DRB Application No.: 06DRB-00908 (FP)
Project Name CAGUA TOWNHOMES
Agent: Wayjohn Surveying Inc.

Project # 1004565
Phone No.: 255-2052

DRB Application No.: 06DRB-01059 (SBP)
Project Name: CAGUA TOWNHOMES
Agent: Wayjohn Surveying

Project Name: CAGUA TOWNHOMES

SITE PLAN for SUB DIVISION
SCALE: 1" = 10'

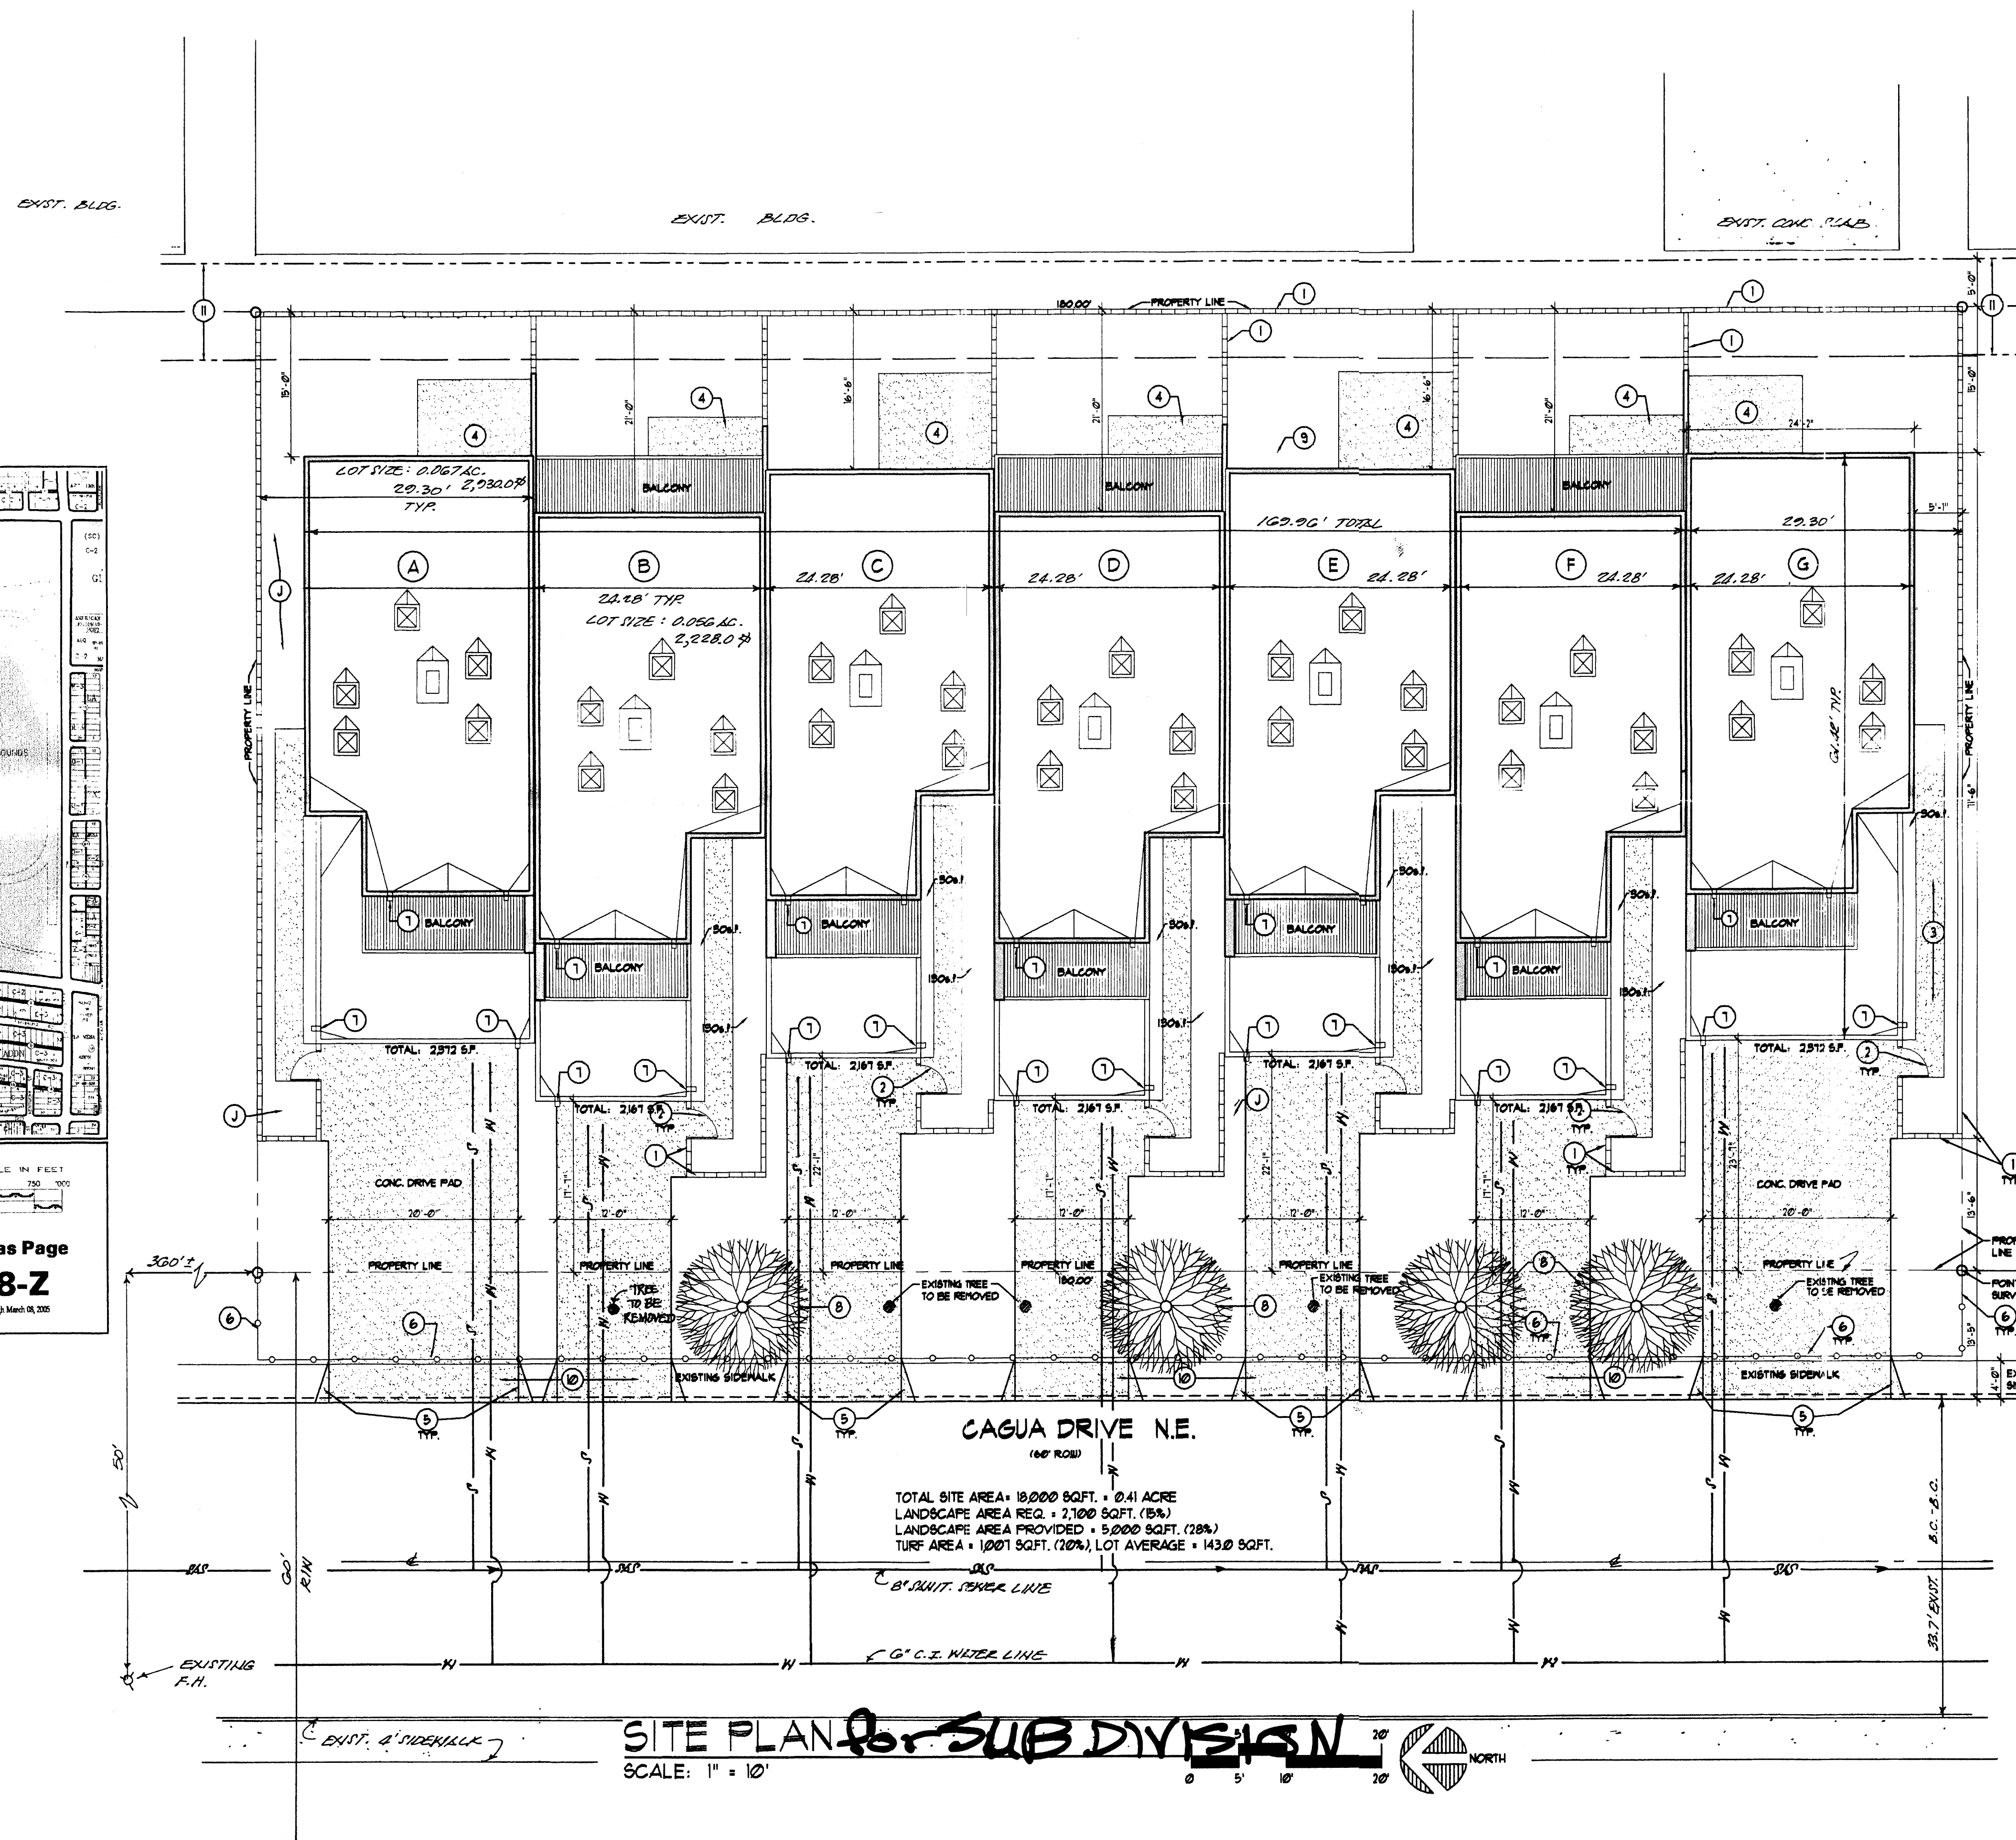
UTILITIES: Remove water/sewer service lines
